From: Amanda Scholes on behalf of Planning.Responses
Sent: 01 April 2021 08:36
To: Planning Scanning
Subject: FW: P/29/21/DOC - Approval of details reserved by condition imposed under ref P/58/15/OUT relating to Condition No 14 - highway works. Land To North And South Of Summer Lane Pagham PO21 4NG

Subject: P/29/21PL - Approval of details reserved by condition imposed under ref P/58/15/OUT relating to Condition No 14 - highway works. Land To North And South Of Summer Lane Pagham PO21 4NG

PROJECT SUMMER LANE, PAGHAM				CLIENT HANBURY PROPERTIES LTD	
DRAWING TITLE SECTION 278 HIGHWAY WORKS				vectos. 4th Floor Oxford Place, 61 Oxford Street, Manchester, M1 6EQ	
DRAWN AM	CHECKED PW	DATE 16.02.2021	SCALE AT A1 1:200	DRAWING NUMBER VD16396-ID-SK-0005	REVISION A

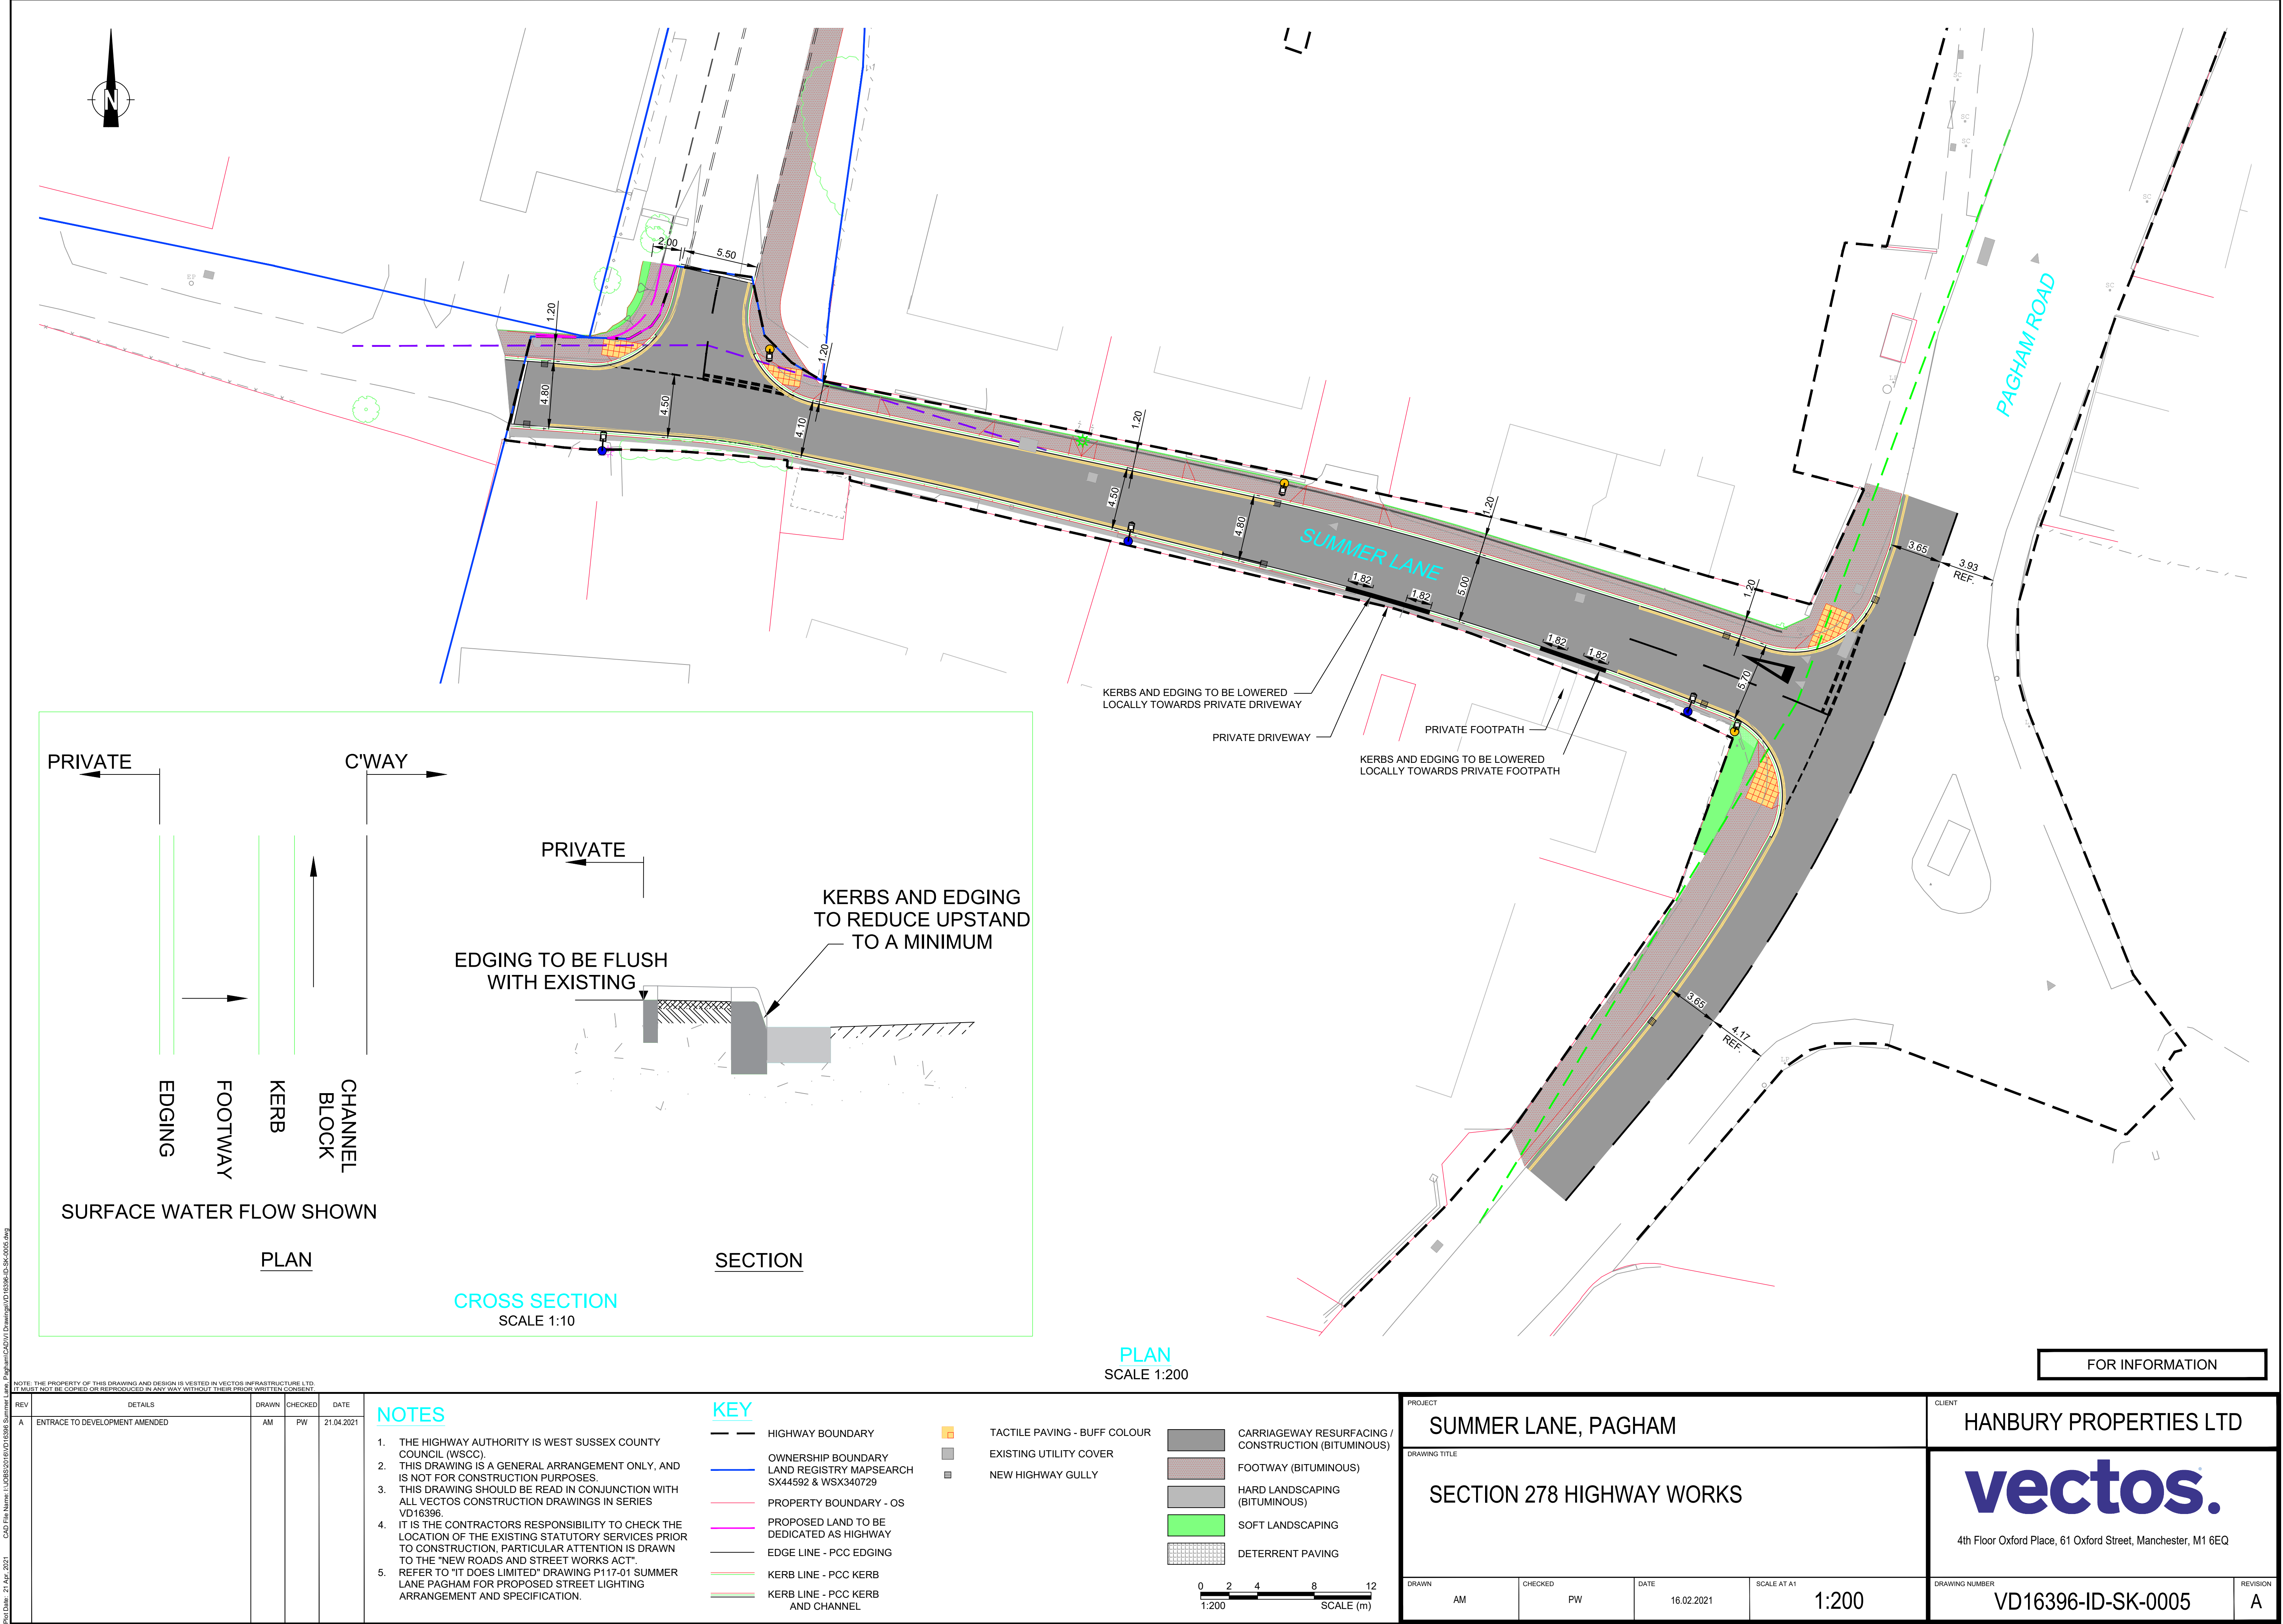
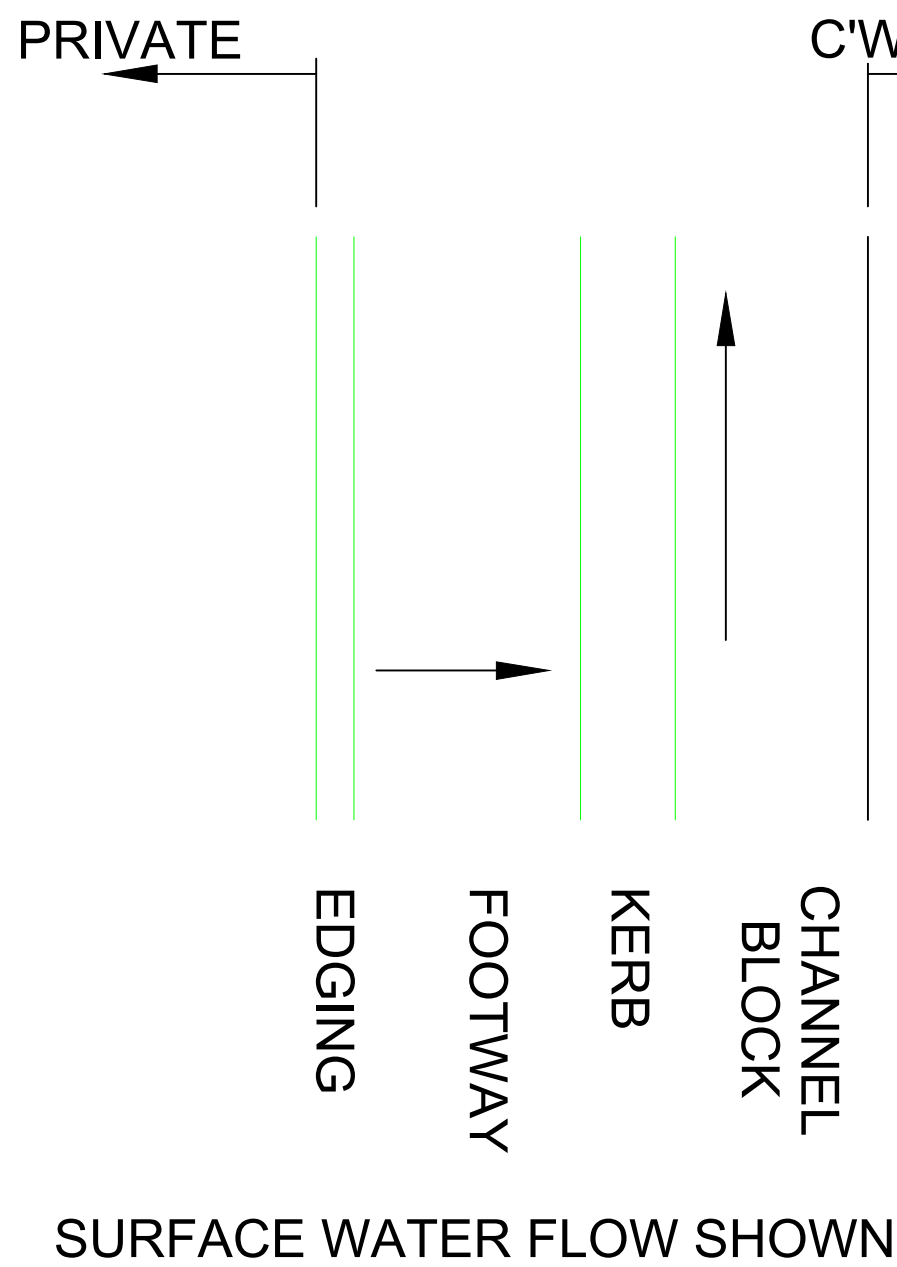
Having now checked the position with my clients I can tell you that our position is that this part of the access as constructed on the site is different from that shown on the access plan approved under P/58/15 OUT, the access plan approved under P/70/19 RES and that shown on the drawing submitted under this application and is therefore unauthorised as it does not benefit from the necessary planning permission.
